# CITY OF ALBUQUERQUE

**Re: National Electric, 2200 Midtown Plaza NE  
2200 Midtown Pl NE  
Request Permanent C.O. - Accepted  
Engineer's Stamp Dated 8-1-15 (File: G16D095E)  
Certification dated: 7-22-16**

**Re: National Electric  
Grading and Drainage Plan  
Engineer's Stamp Date 8/1/2015 (G16/D095E)**

RE: **National Electric, 2200 Midtown Plaza NE**  
**Grading and Drainage Plan**  
**Engineer's Stamp Dated 5-06-15 (File: G16-D095E)**

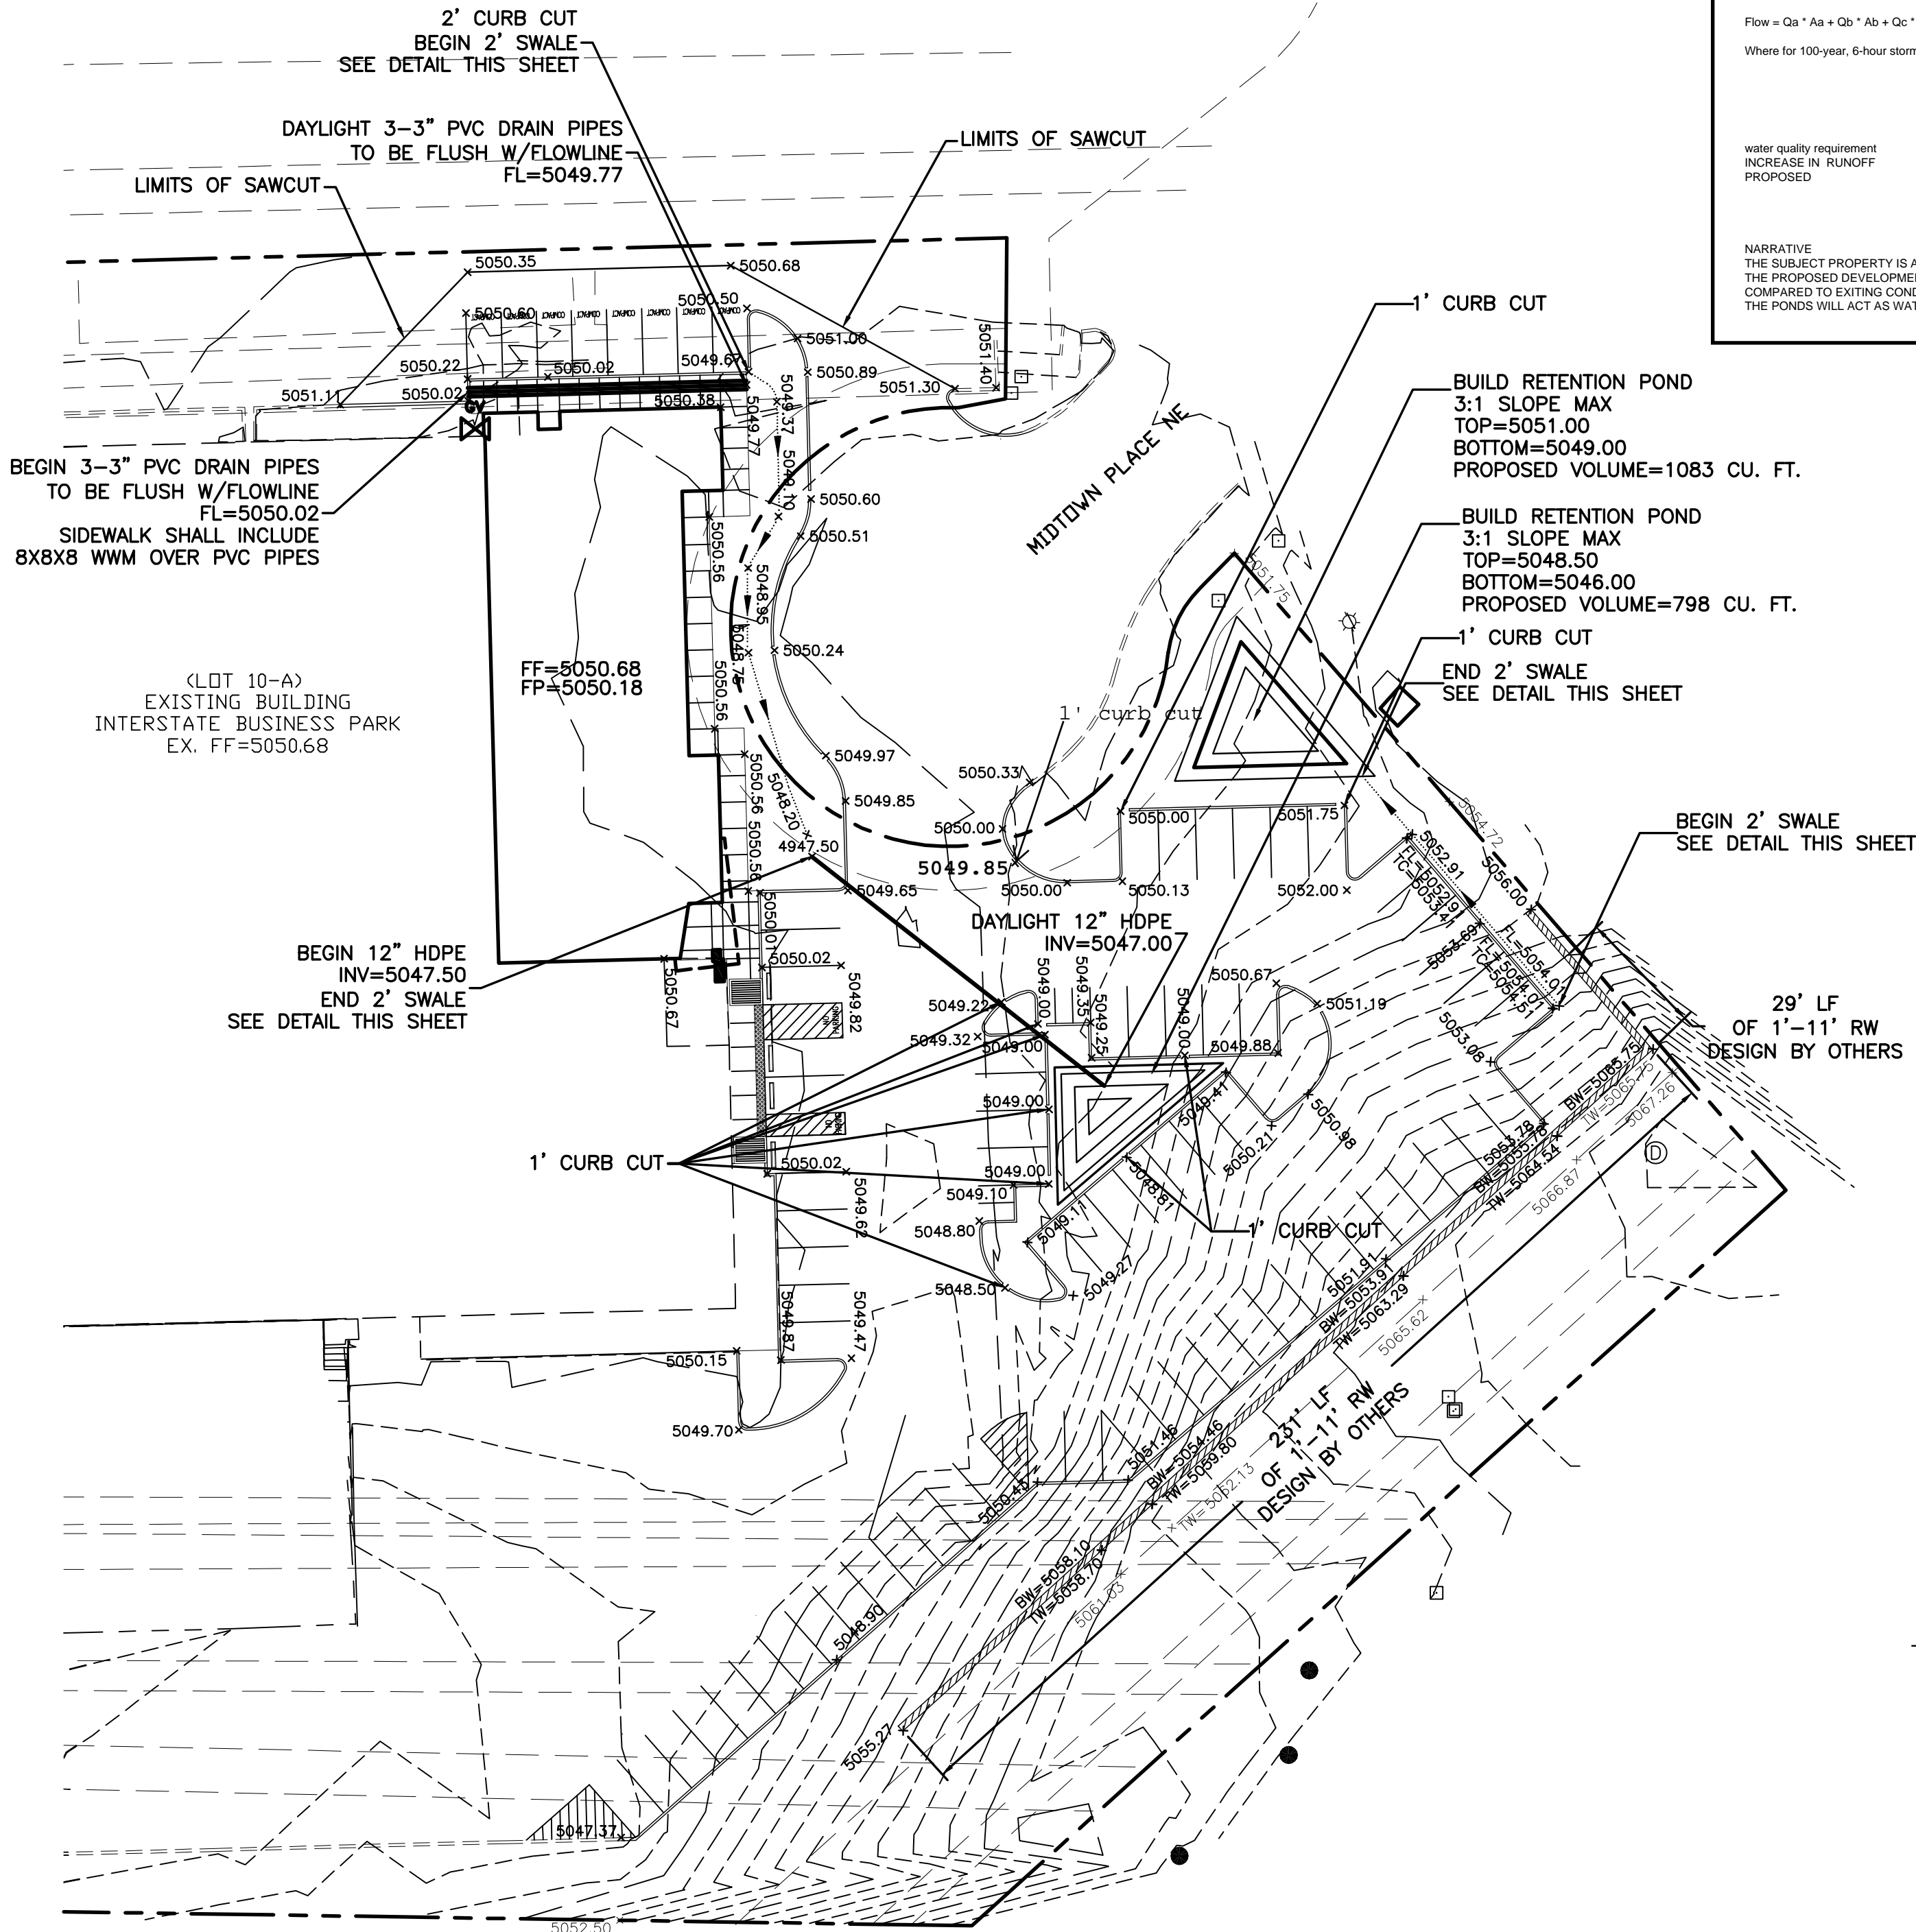
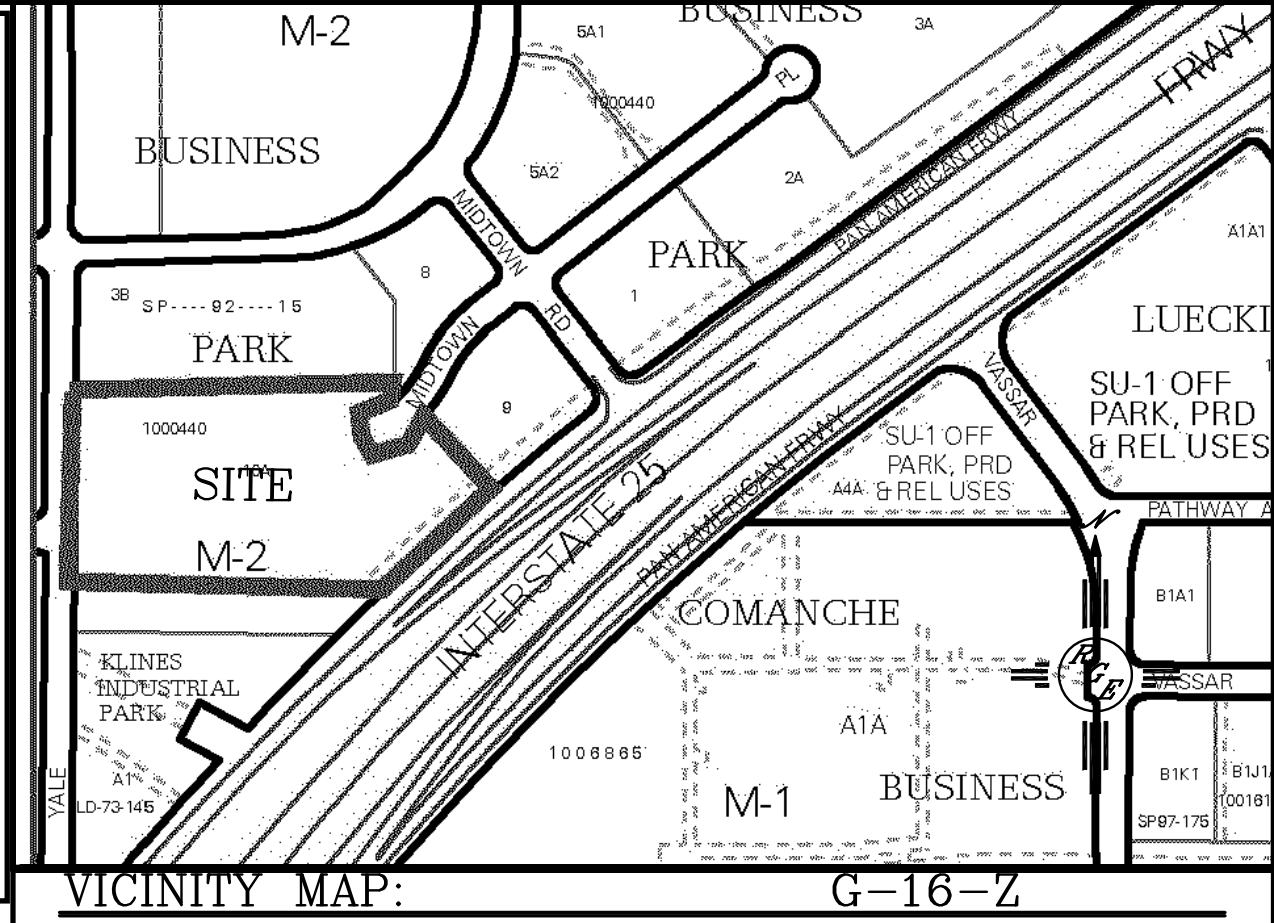
- 1) Show basin boundaries for the provided basin computations, and show where new improvements end and tie into existing facilities.
- 2) Label existing contours and the new contours for the ponds.
- 3) Show swale from 5049.85 spot elevation at entryway to the pond on the north side of the site.
- 4) Show existing and new roof drains.
- 5) In the "Drainage Narrative", mention overall acreage of the site, and explain that historical flow patterns for the site remain the same if this is the case. Discuss the off-site flows from Midtown Place that the site is accepting, and reference the prior drainage report. Mention that the new retention ponds retain the volume of increased runoff from existing conditions.
- 6) Label 100-year storm flow that each of the new on-site pipes is conveying and the pipe slope. Demonstrate capacities.

1. We have provided a basin map and labeled project limits
2. We have labeled the pond contours
3. We have shown a swap form the 5049.85 at entry to the pond on north side of site.
4. We have shown the roof drains
5. We have updated the drainage narrative to discuss upland flows and retention volumes.
6. We have labeled the flows in the pips and included calculations for capacity in the
